Application No: BN/41/22/DOC
Registered: 4th April 2022
Site Address: Magnolia Cottage Fontwell Avenue Eastergate PO20 3RZ
Description of Works: Proposed two storey rear extension BN/4/21/HH Conditions(s) 3

At this stage we **would not recommend discharge of conditions** until the following comments are addressed.

Trench soakaway using Polystorm Lite Geomodular units  
Landscaped areas only  
0.4m deep

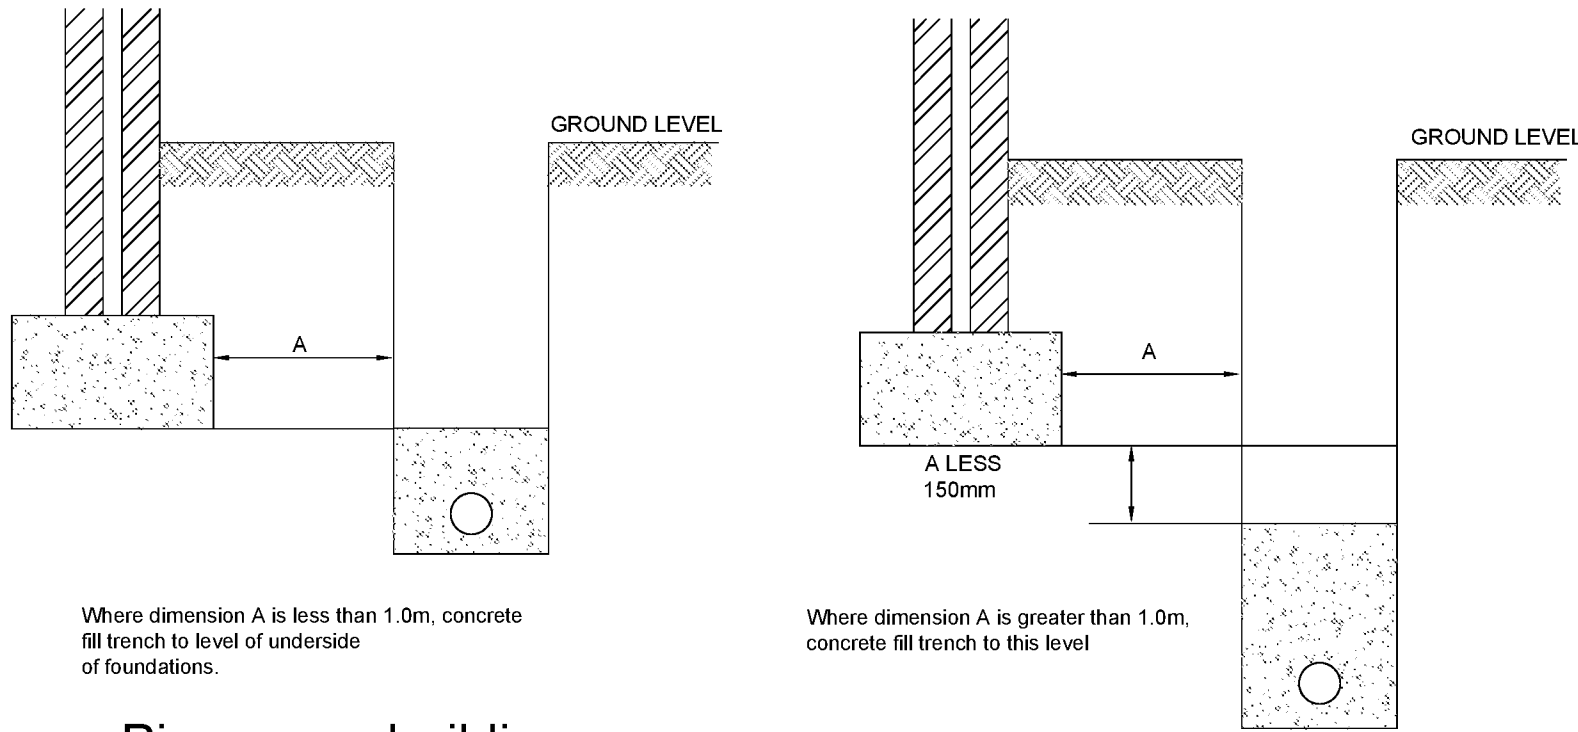
- The access point for carrying out maintenance and inspection of the soakaway should be stated, (and details given if this is an additional element of the design e.g. additional manhole).

4. The incoming pipe invert level is potentially below the 1:10 year water level within the soakaway. The applicant should confirm that the pipe is not likely to be surcharged during the 1:10 year storm. Or the pipe could be raised to provide a larger difference between the soakaways invert level and the pipe inlet invert level, or additional crates included within the design, to lower the 1:10 year water level.

5. The applicant should confirm that the soakaway is outside of the root protection zone (RPZ) for the trees located on the land where the soakaway is proposed.

450mmØ POLYPIPE BASIC  
SILT TRAP DETAIL

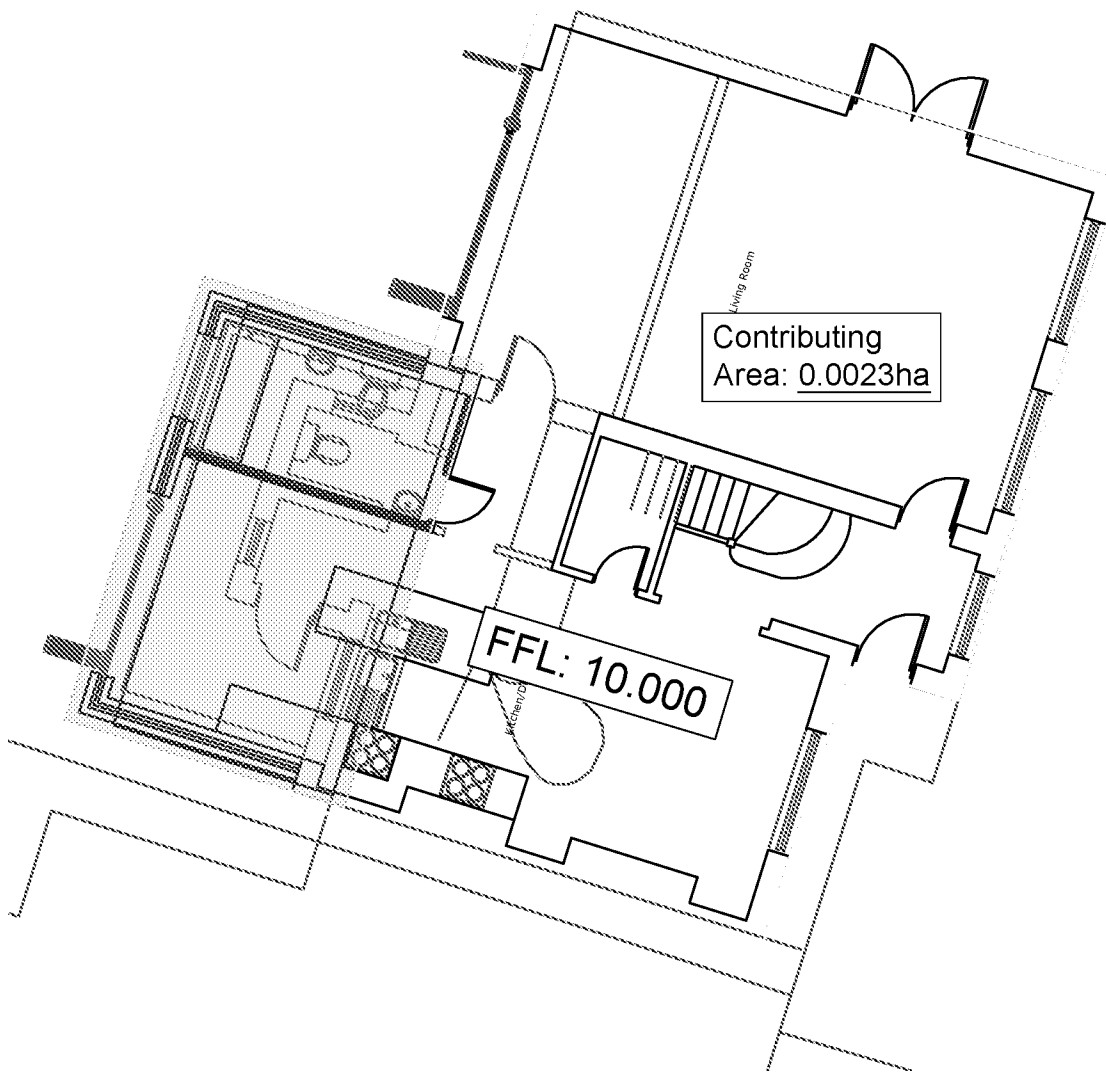
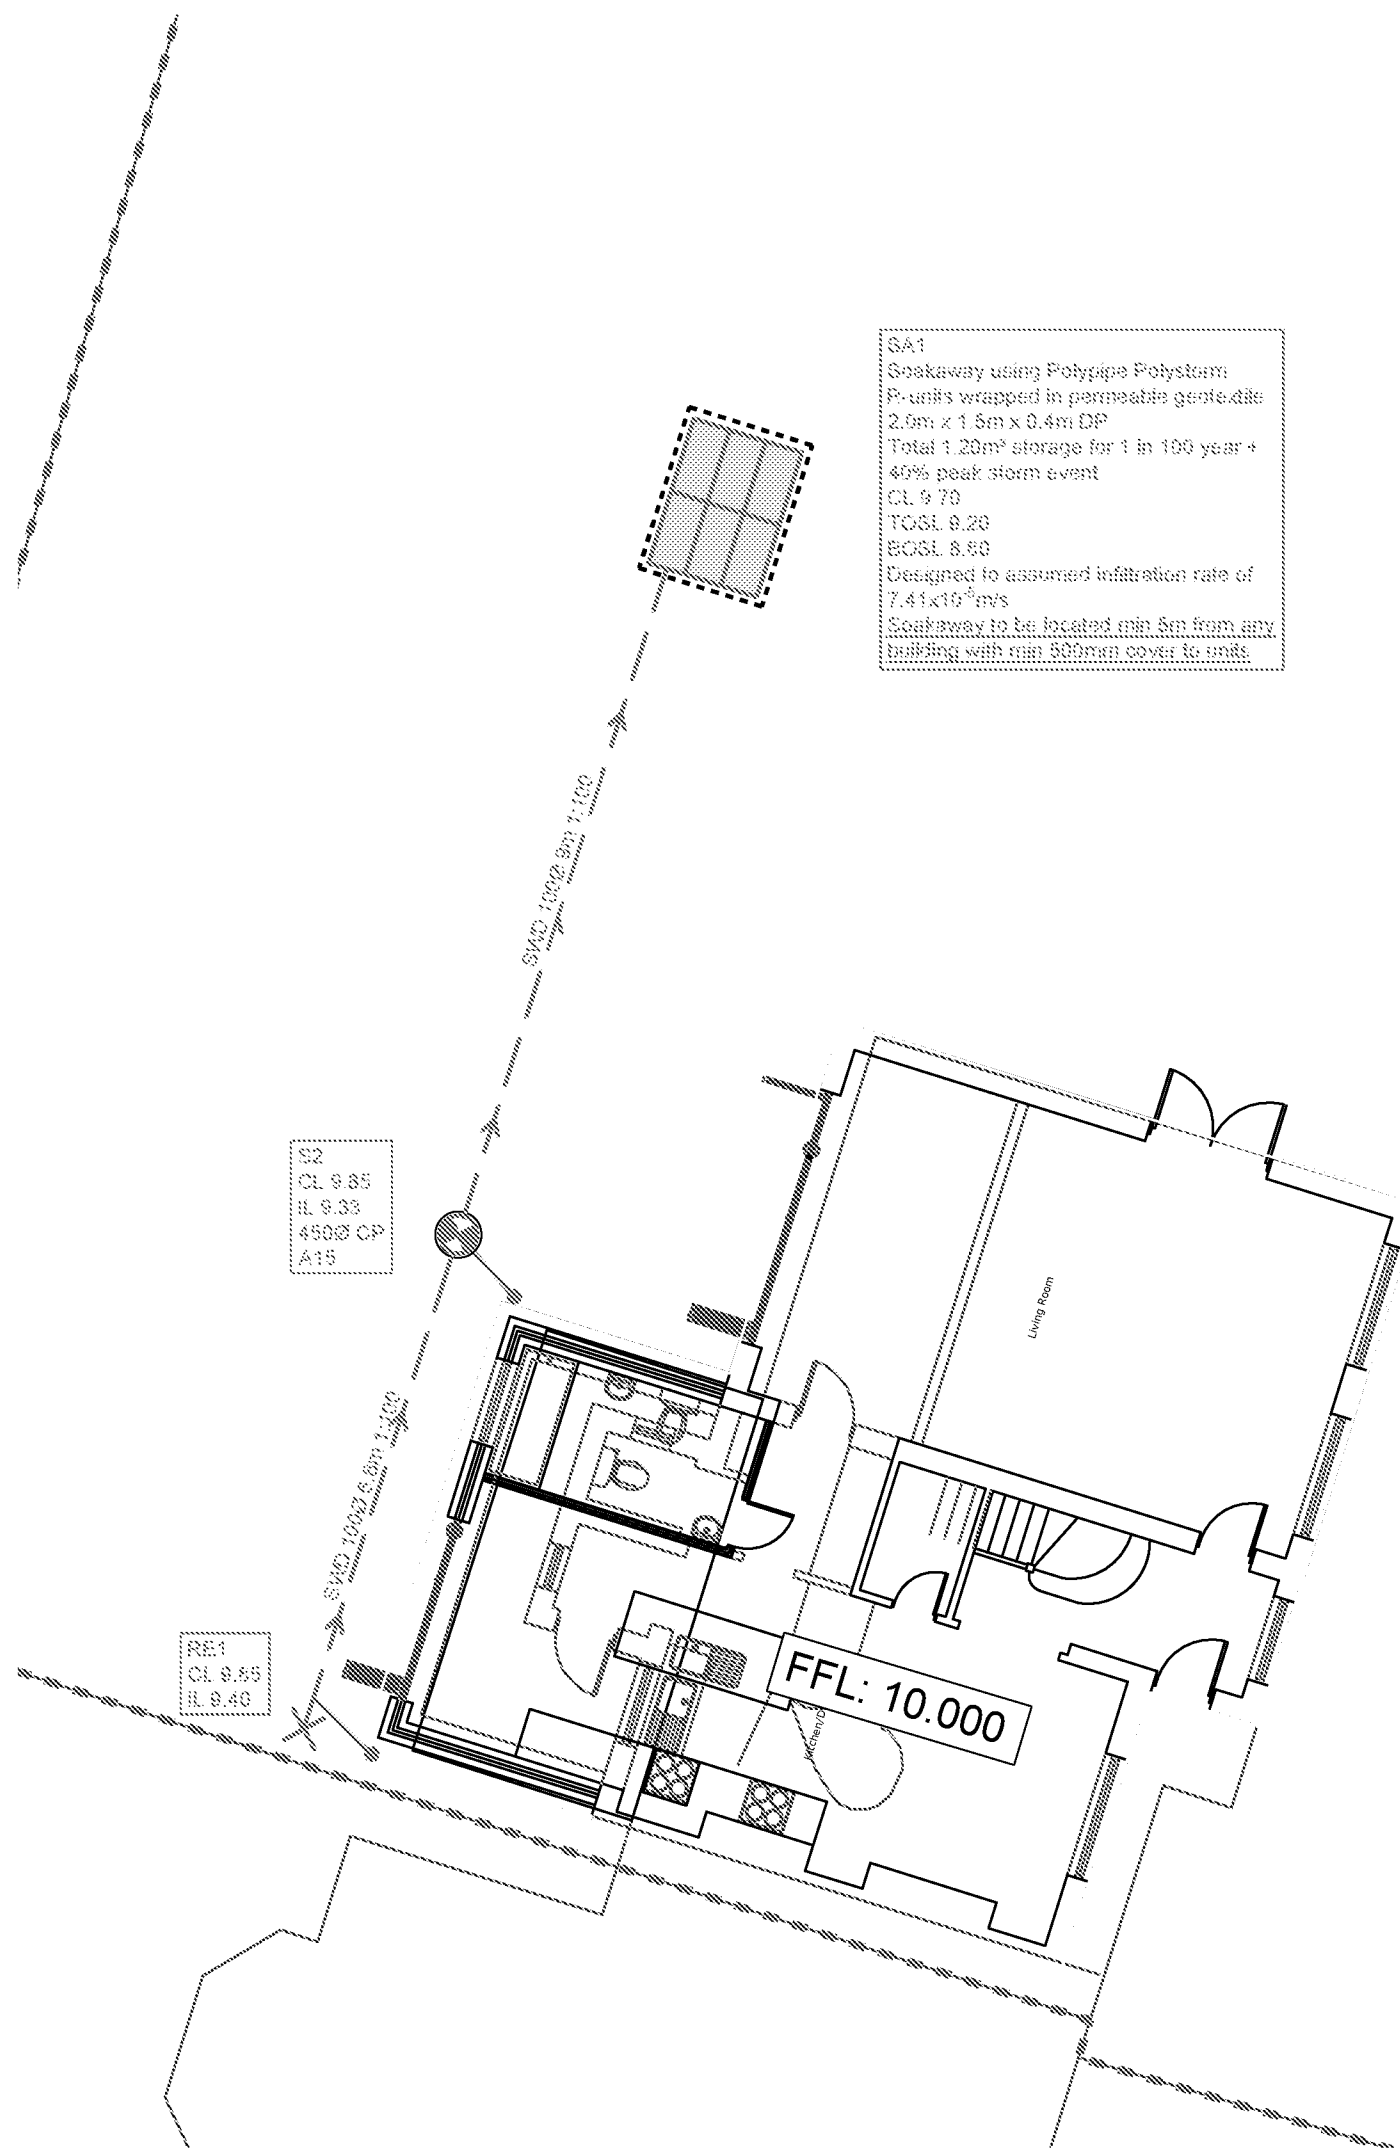
1. Additional information is required on the design drawings.
 - The loading class for the cover on the sediment trap manhole (and any other manholes) should be stated.
